COLLYWESTON PARISH COUNCIL

Our ref: 20/Planning/11

Your ref: WS010005_000008_200702

Re: Application by Augean South Limited (the Applicant) for an Order granting Development Consent for the Proposed East Northants Resource Management Facility Western Extension (the Proposed Development)

Approximate location of the agreed landscape and visual impact assessment viewpoints

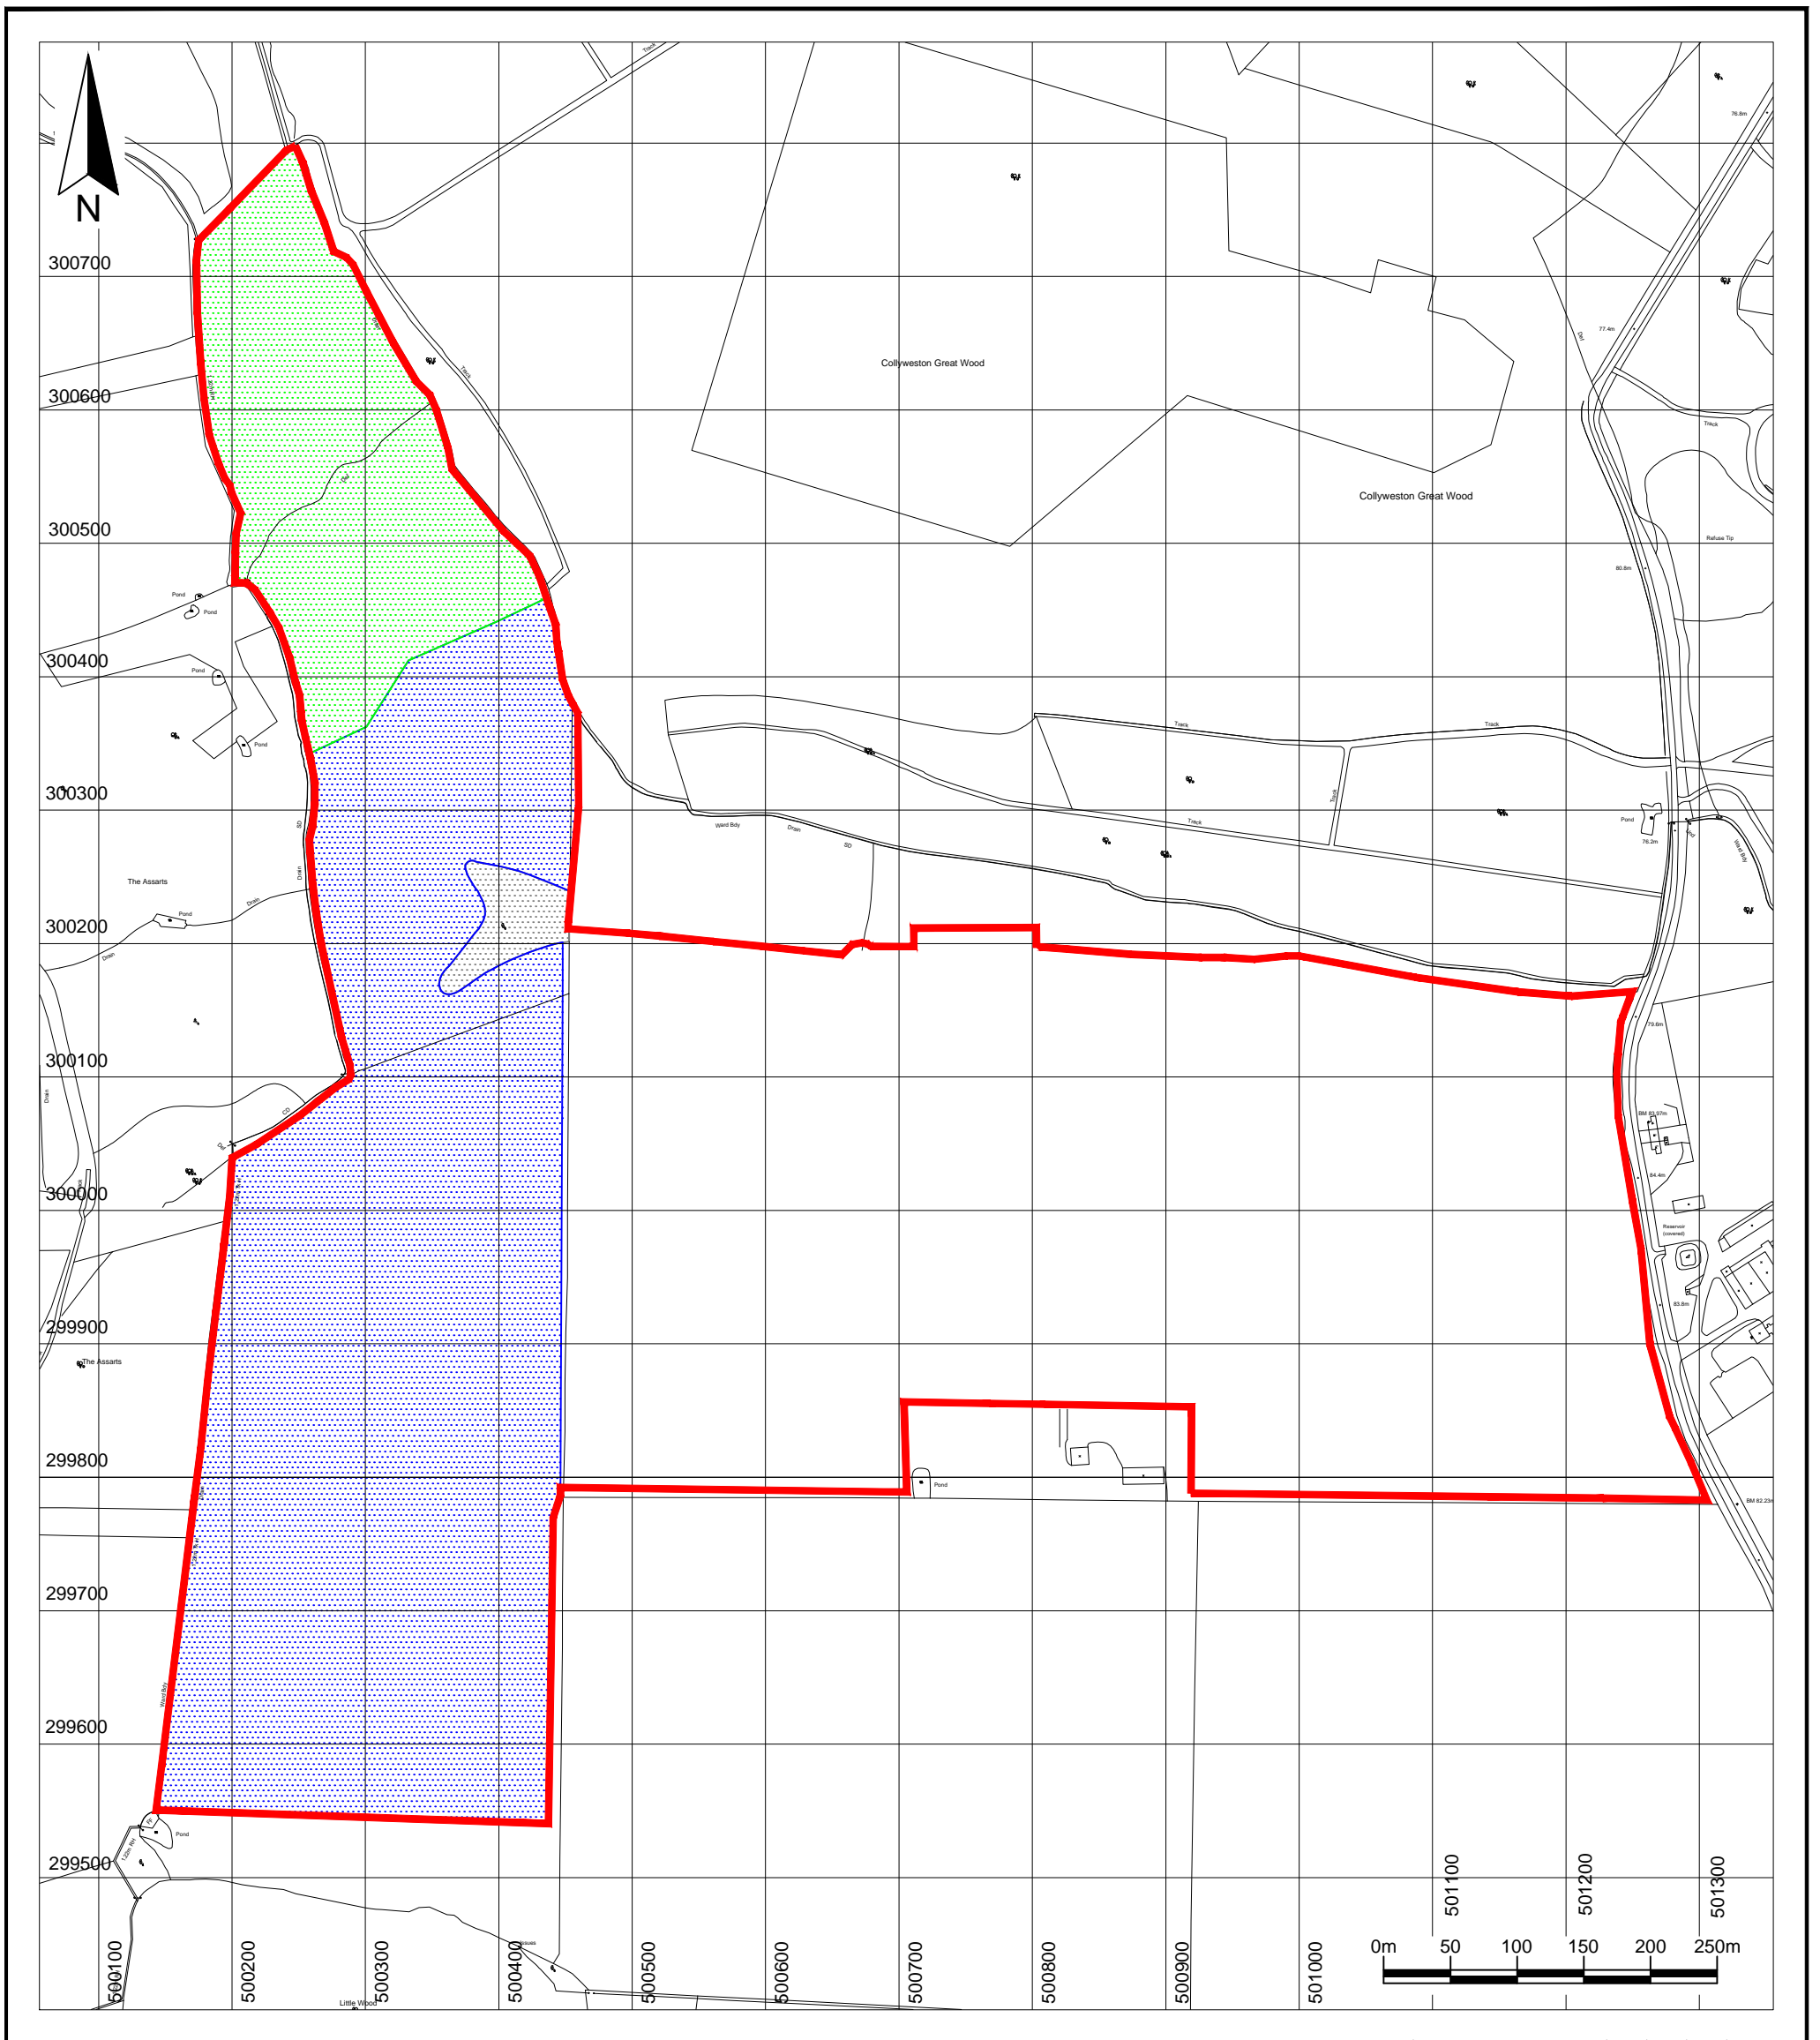
- (d) **Land to the South West:** It is unclear on what it was decided not to carry out Noise Assessment to the South West of the site. Noise impact may not be anticipated to affect *people* in this area, but it has just the same impact on wildlife here as in all of the surrounding areas.
